Site plan

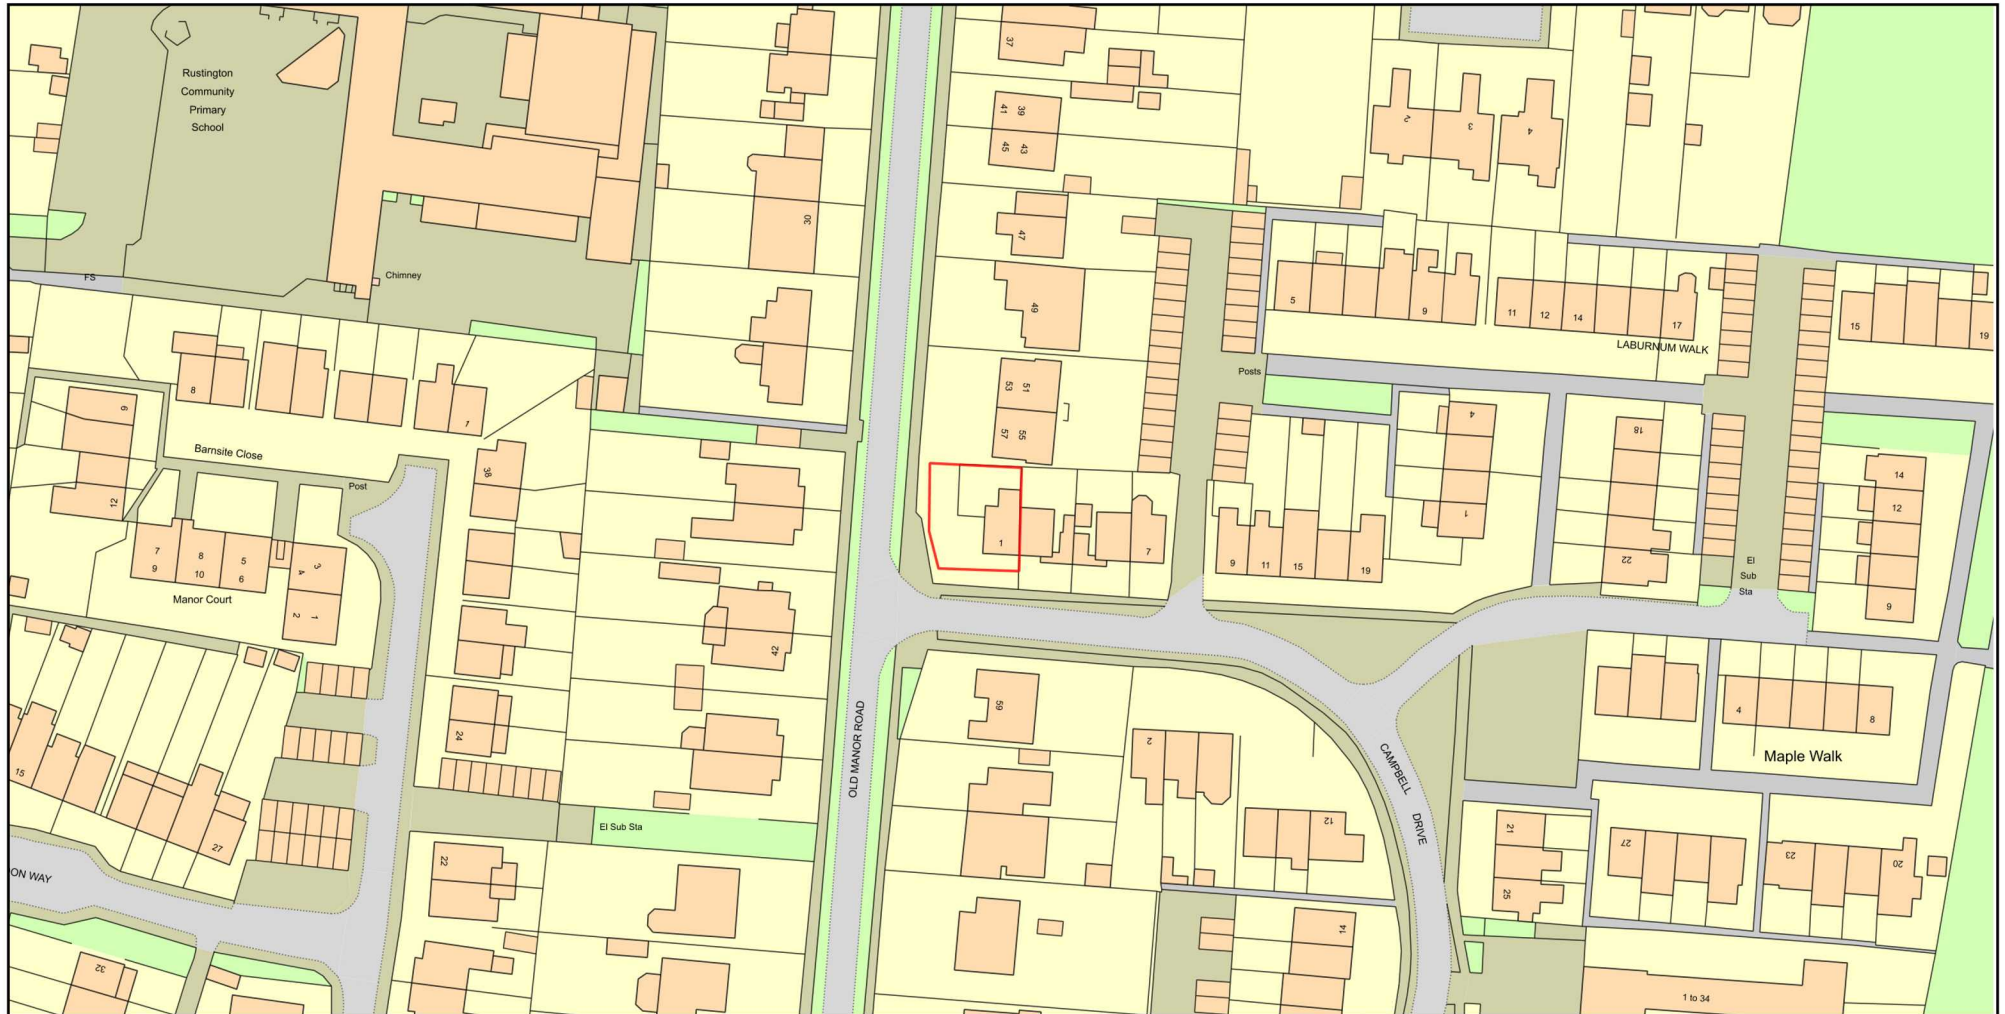
I would also advise that you indicate on the attached plan that the hatched line is the line of the new fencing.
